PLANNING AMENDMENT

THE POPLARS, HOF'S GATE, MOULTON

Re-siting of dwelling 3 metres to north,
deletion of rear covered walkway and
alterations to fence/retention at rear.

Amendment: Resiting of dwelling 3 metres to north, deletion of rear covered walkway & alterations to fenestration at rear

Proposed Plans and Elevations of  
House at Moulton.  
Sketch Proposal.  
For Mr. & Mrs. H. Baker  
Scale: 1:50/1:100  
Drawn: DRF  
Date: 26-09-02  
1/9331/F

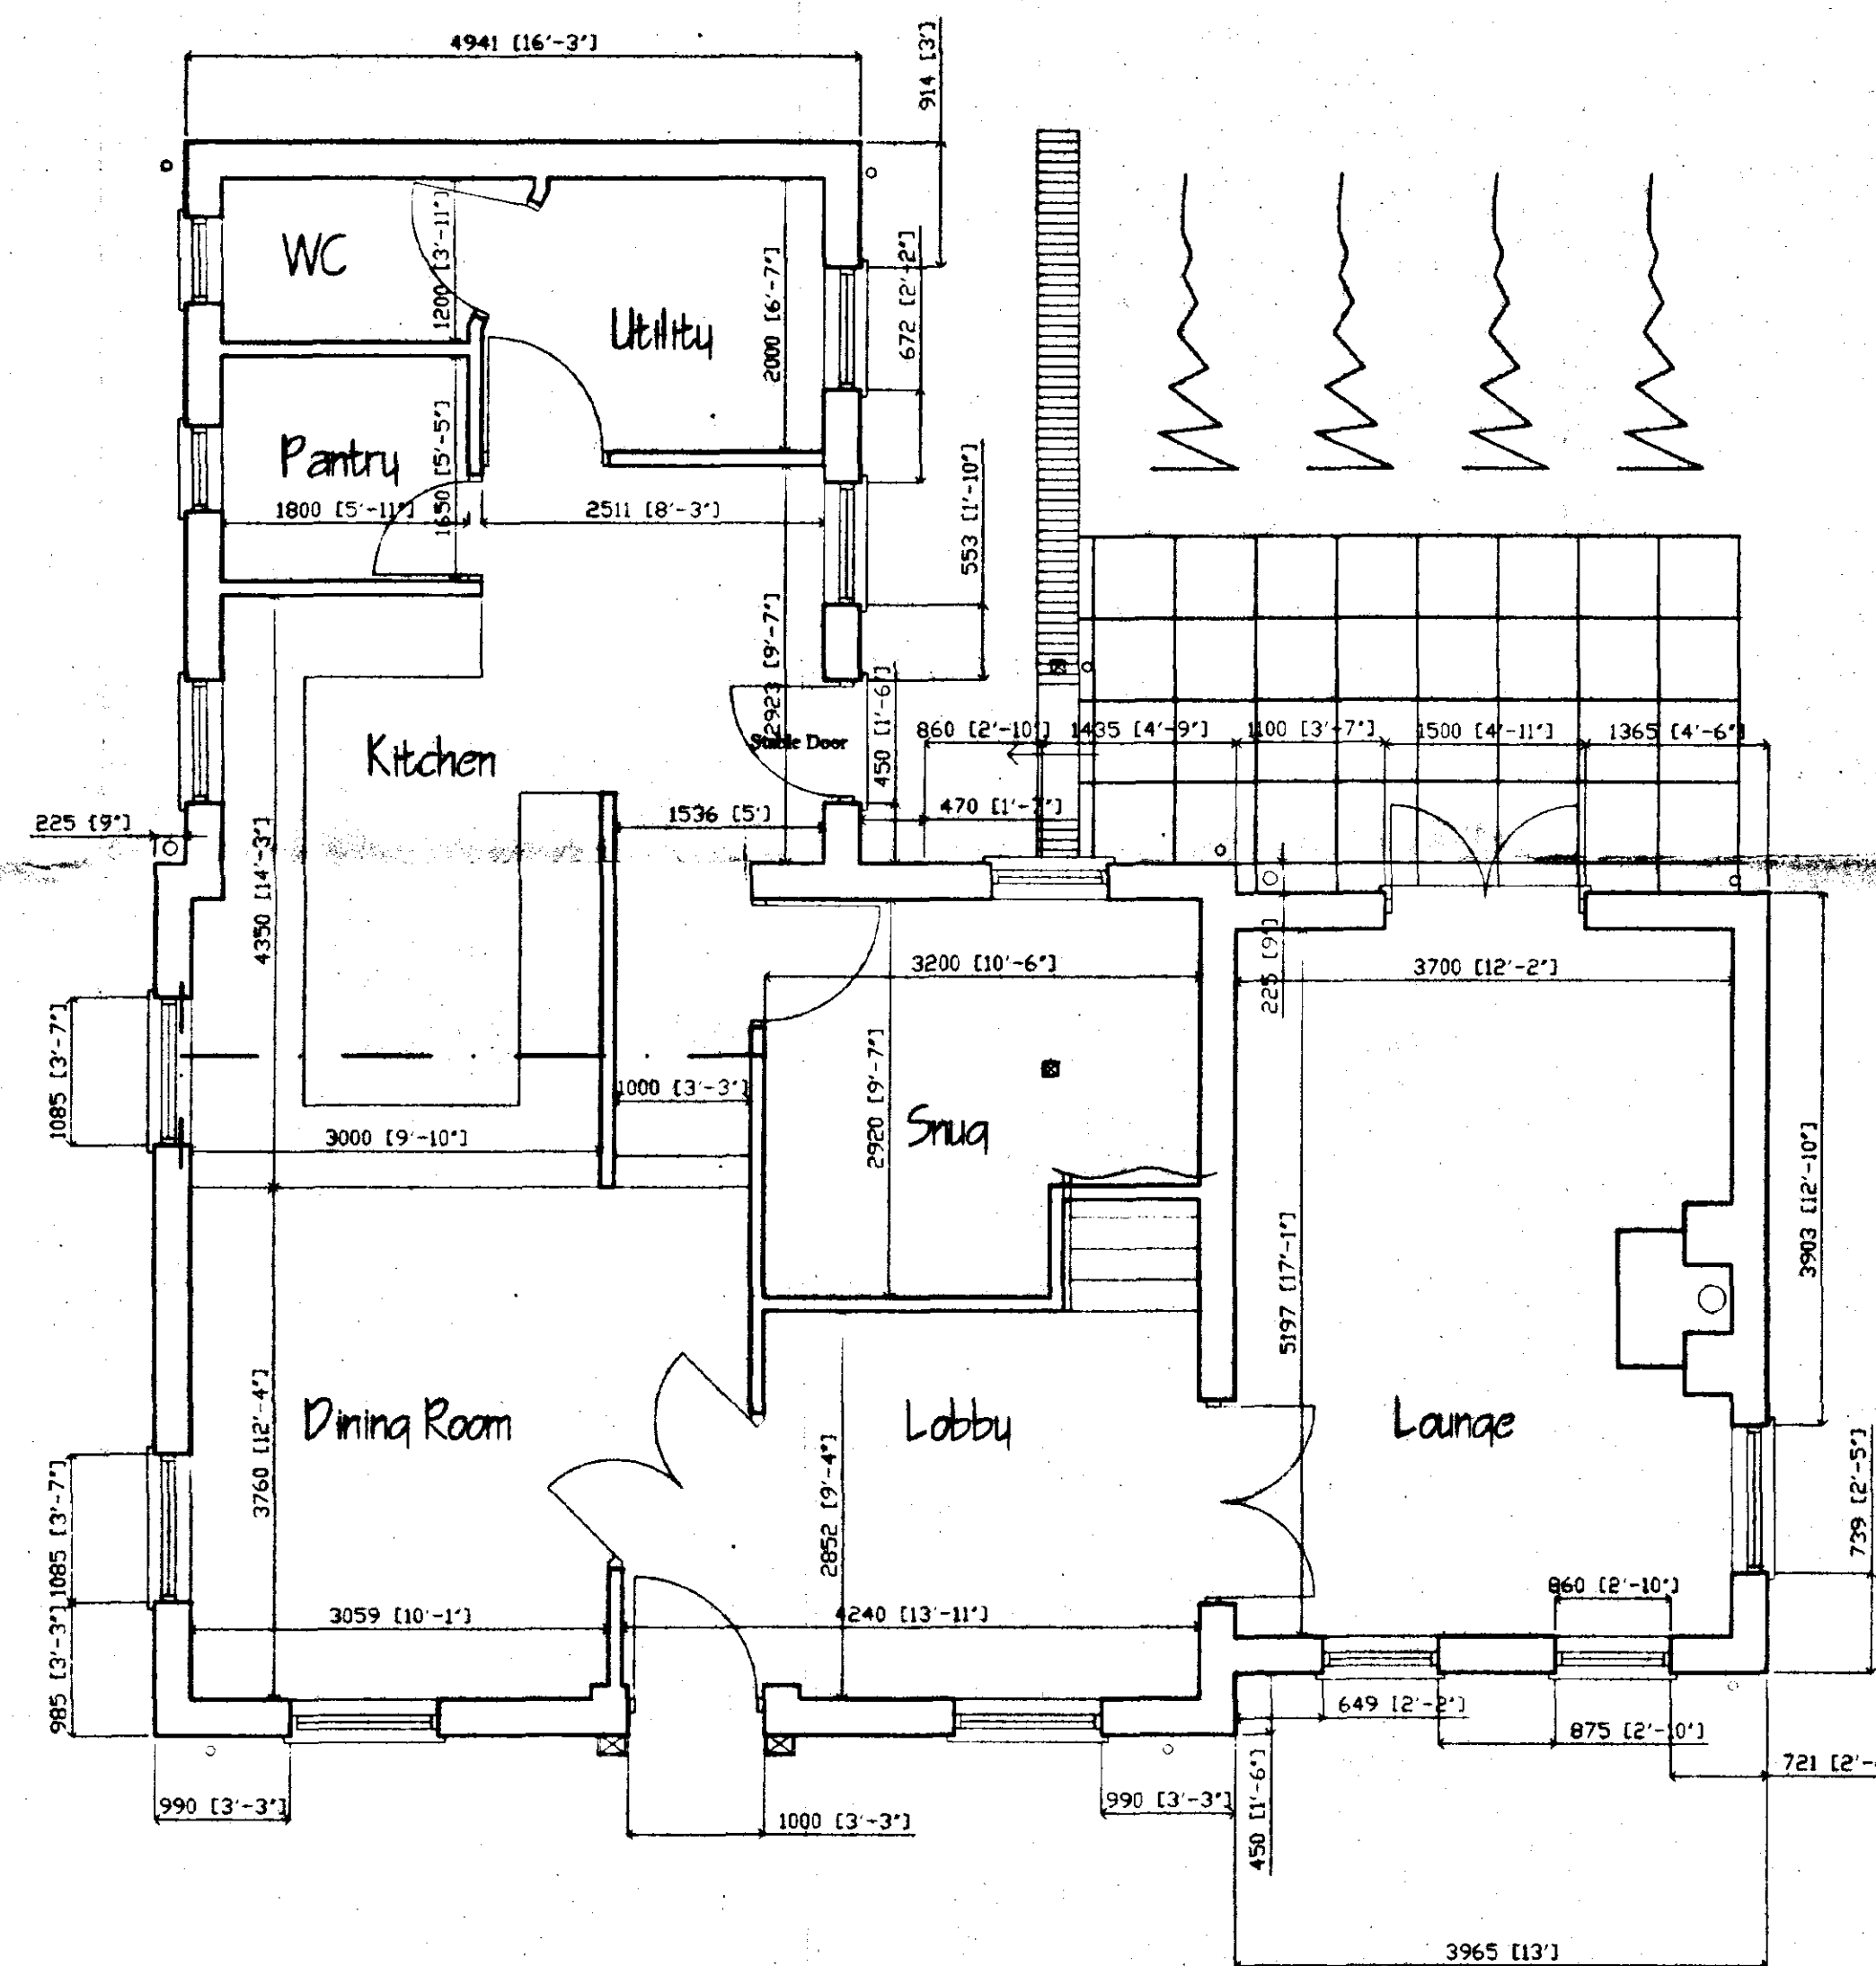
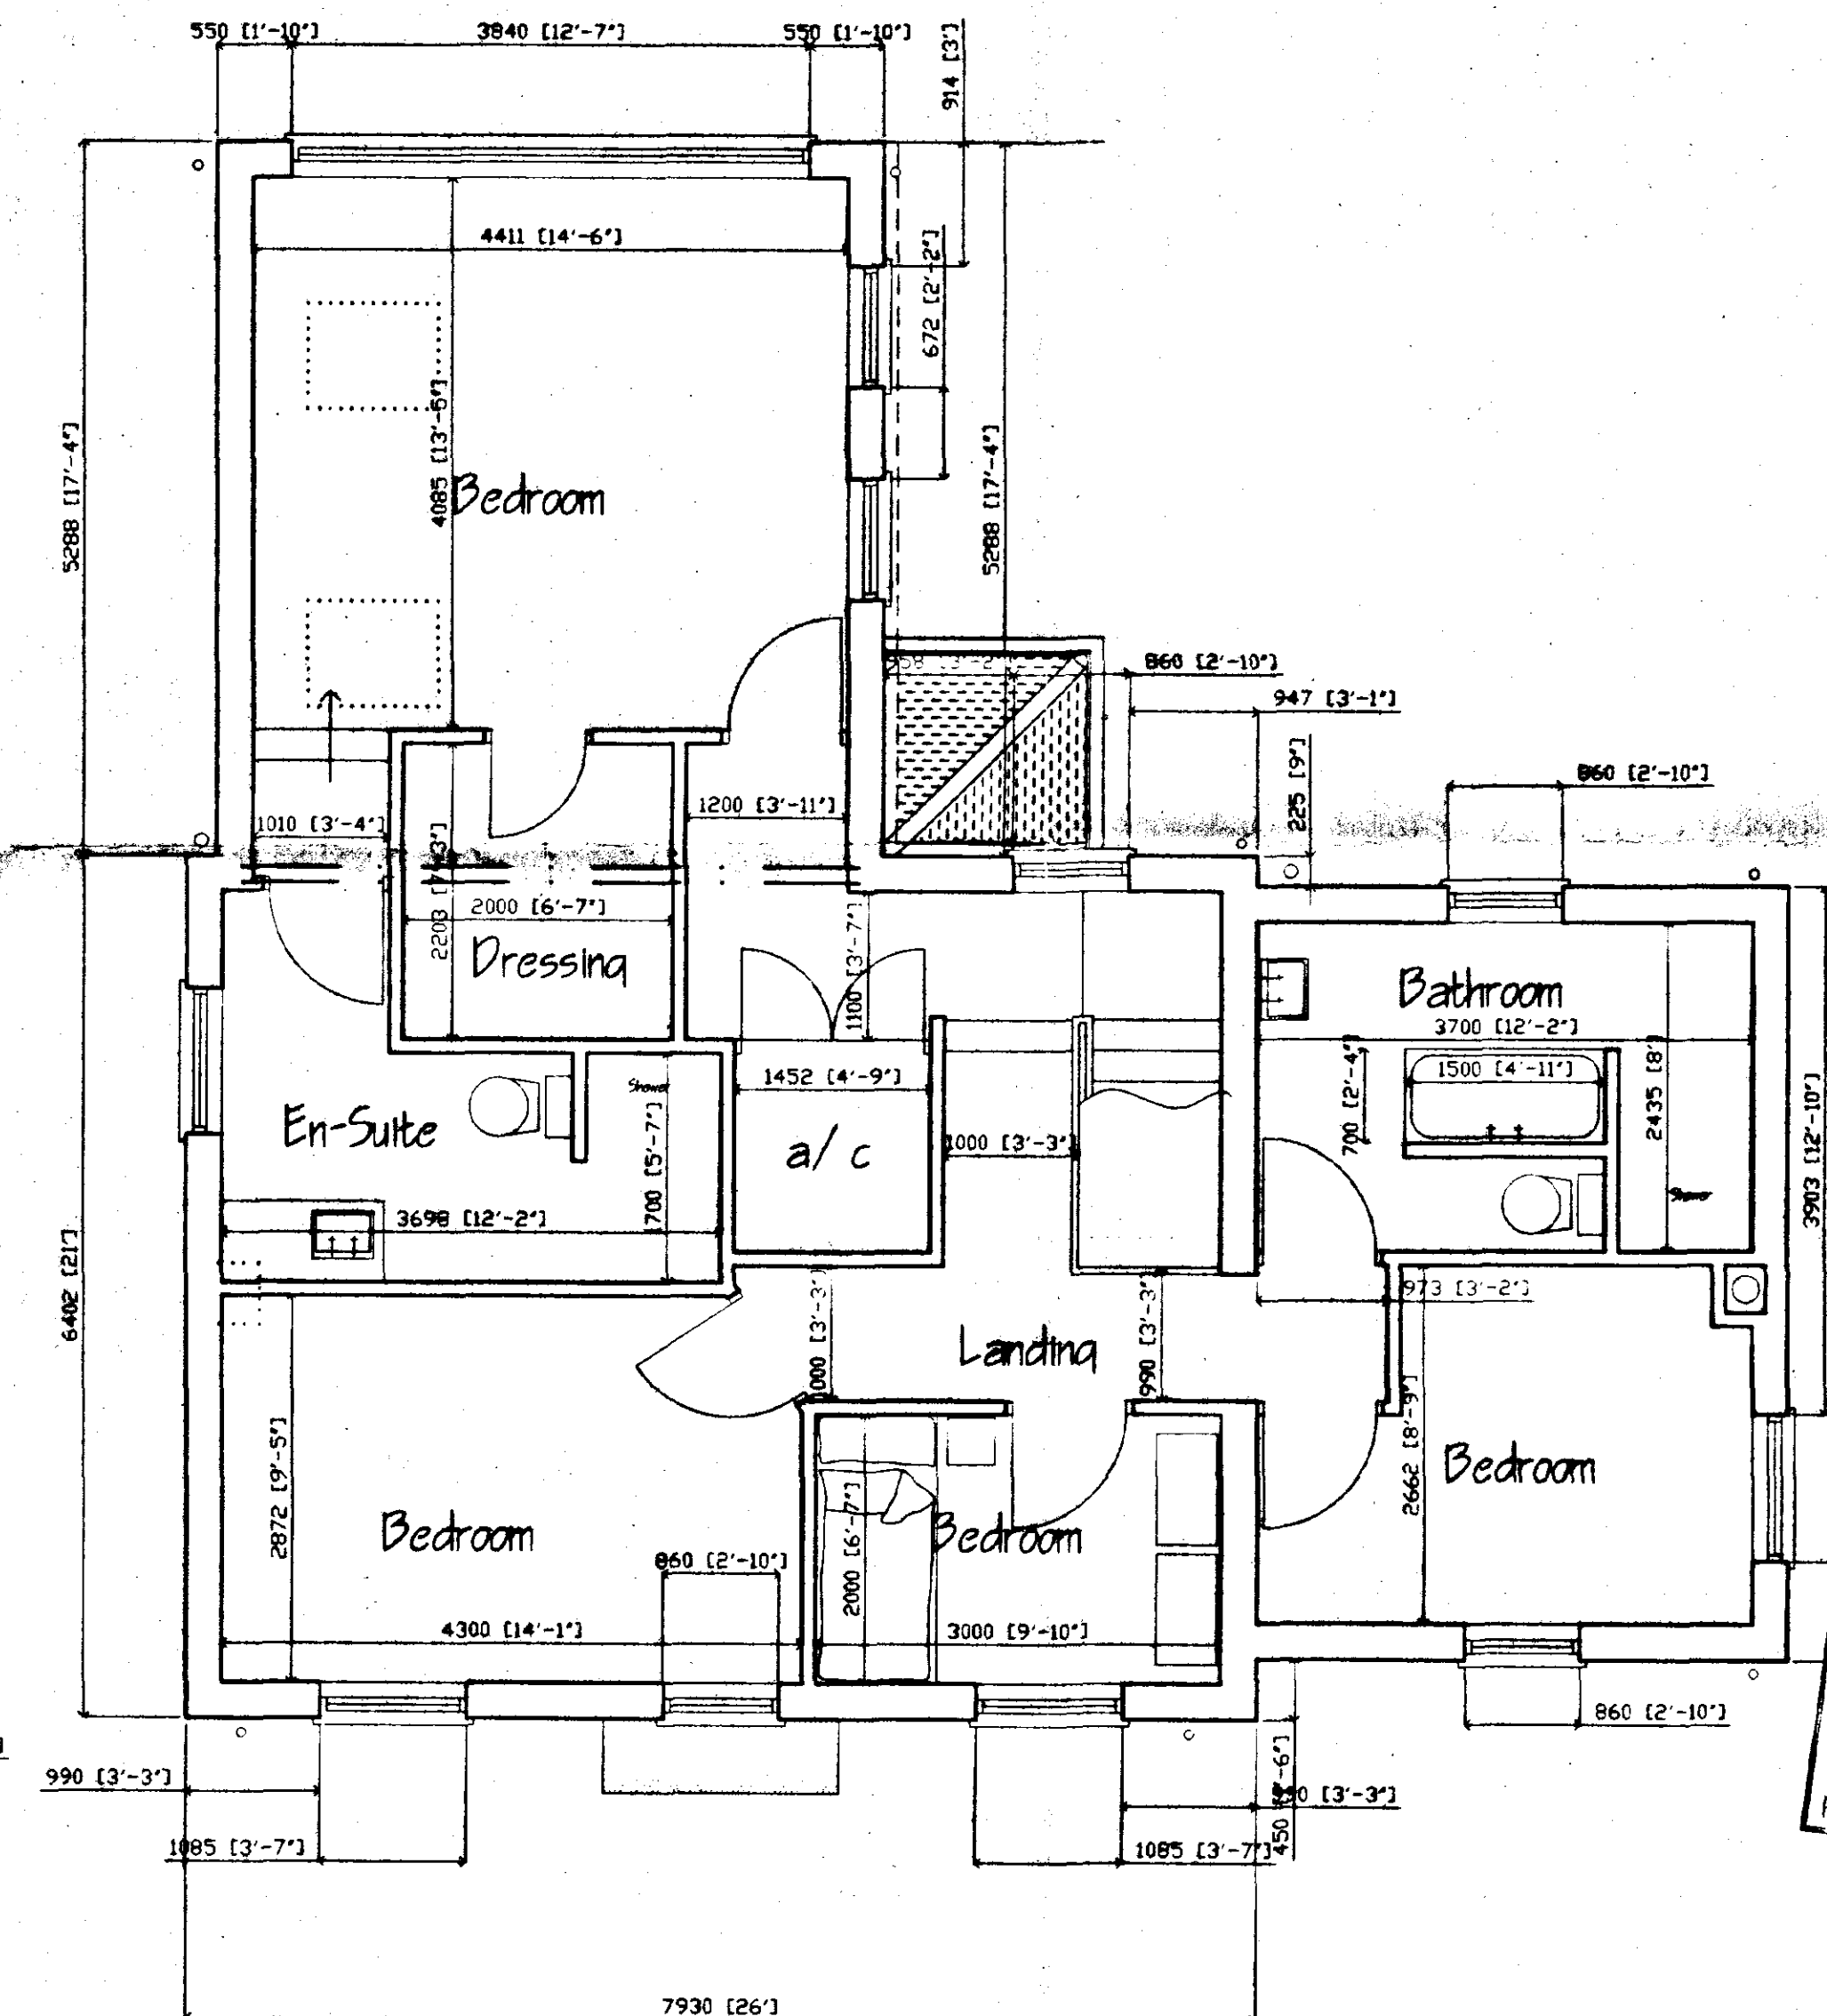
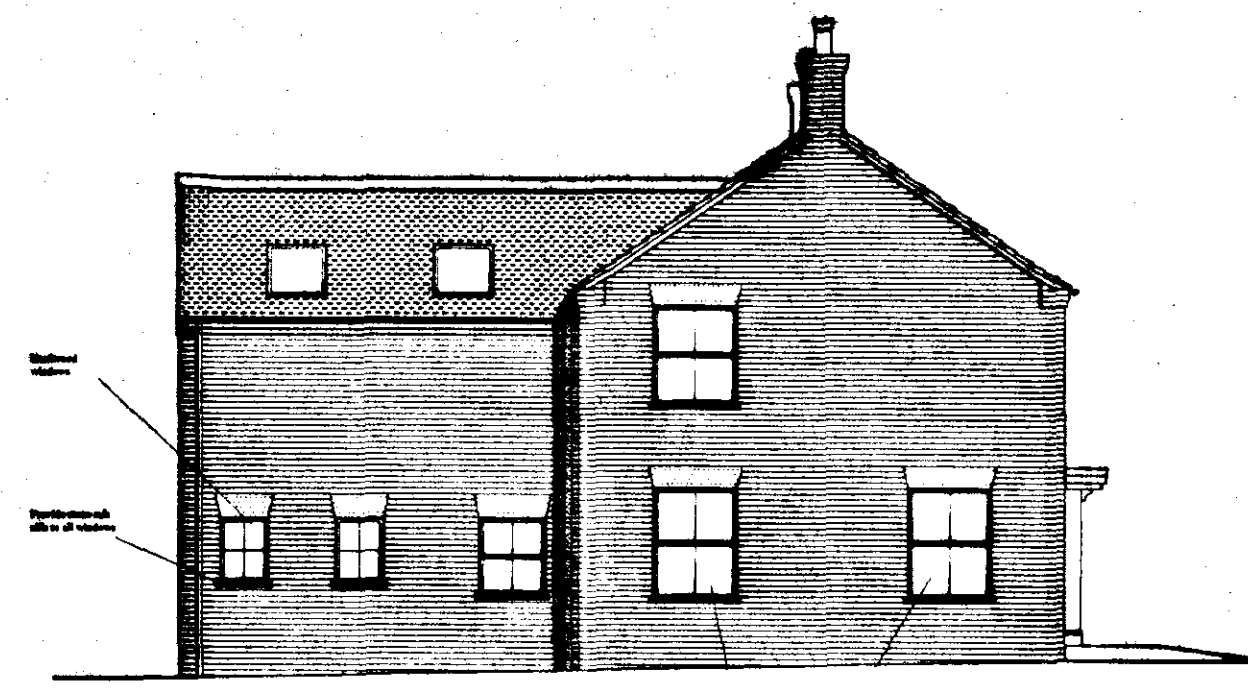
1. The rear covered walkway at ground level on the southern elevation of the rear extension will not be built.
2. The rear door to the property has been moved from the kitchen into the utility room and the gap left by the door will become a window.
3. The siting of the house will be moved approximately 3 metres to the north. This is because we have realised that once built, the view from the main bedroom will be obscured by the roof of the outbuilding.

2. During the process of applying for Building Regulations, it has been noticed that a number of the windows on various elevations need to be moved, and the windows resized. I enclose a plan showing the new elevations and trust that you find these in order. The changes are minimal.

3. When specifying the fireplace for the sitting room, it appears that our architect did not allow for the depth of the aperture. It is therefore necessary to accommodate part of the aperture within the room via the creation of a chimneybreast, and externally, via the base plus chimney being proud of the southern elevation wall.

The amended details submitted in respect of the above proposal have now been considered and there are no objections to the amendment being implemented to the extent described above.

The amended details submitted in respect of the above proposal have now been considered and there are no objections to the amendment being implemented to the extent described above.
